CITY OF ALBUQUERQUE

November 27, 2018

**RE: Primrose School
Grading Plan
Engineer's Stamp Date: 11/01/2018
Hydrology File: C13D029**

Based upon the information provided in your resubmittal received 11/02/2018, the Grading and Drainage Plan is approved for Building Permit and Grading Permit with the following conditions.

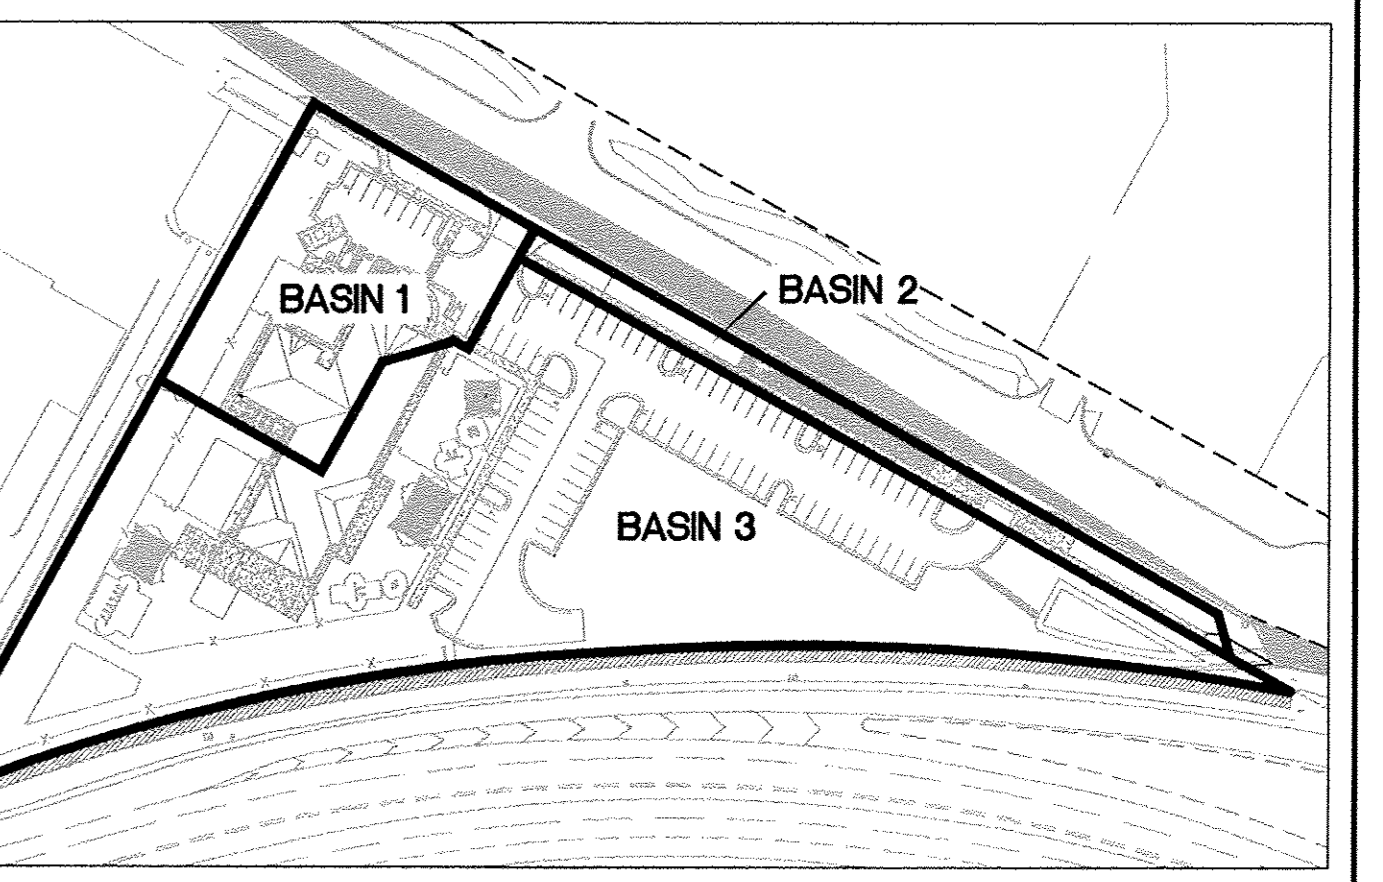
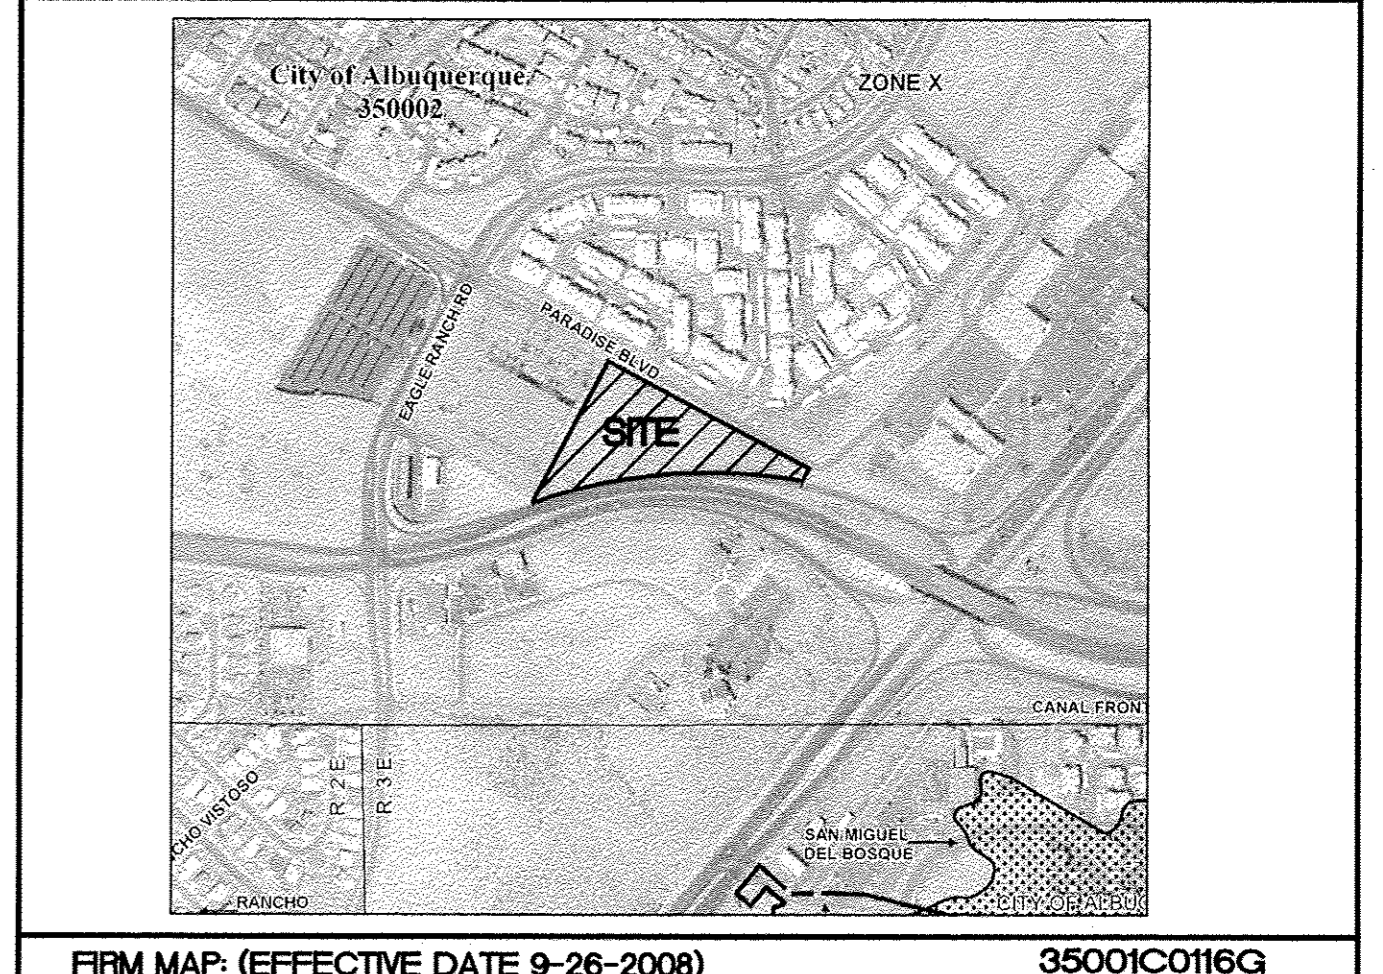
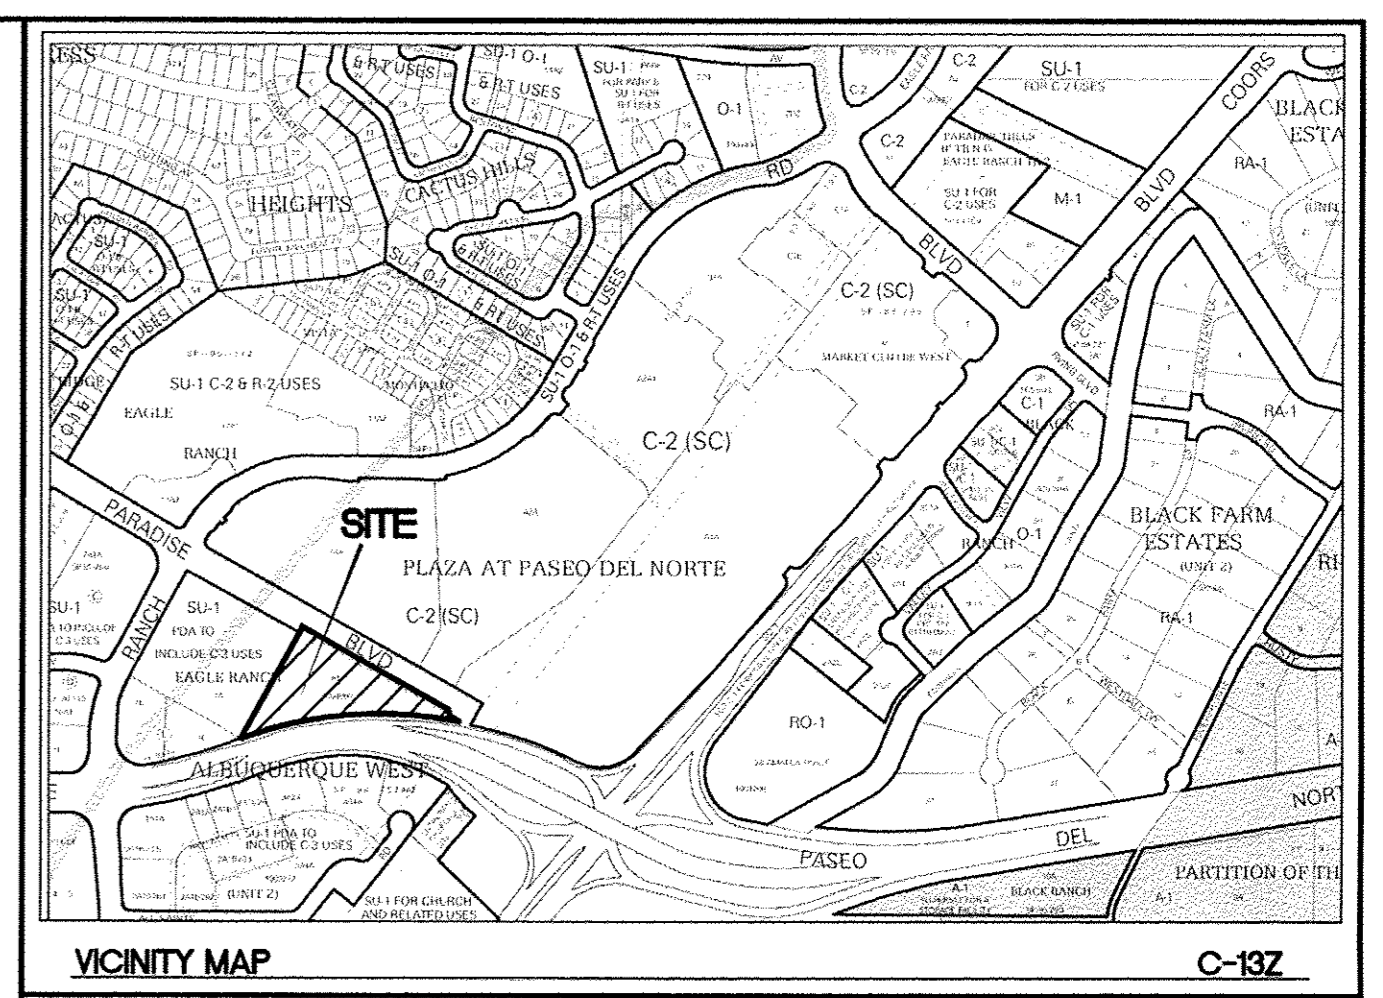
1. Add short piece of curb and gutter across the south edge of the parking lot to prevent drainage from entering the Paseo Del Norte right of way. The shape of the 5047 contour indicates that the curb is there, but the lines for the curb need to be added to the plans.

2. The work order plans need to show the back of sidewalk 1.12' above the flow line of the C&G along Paradise Blvd. with non-erosive landscape material between curb and sidewalk.
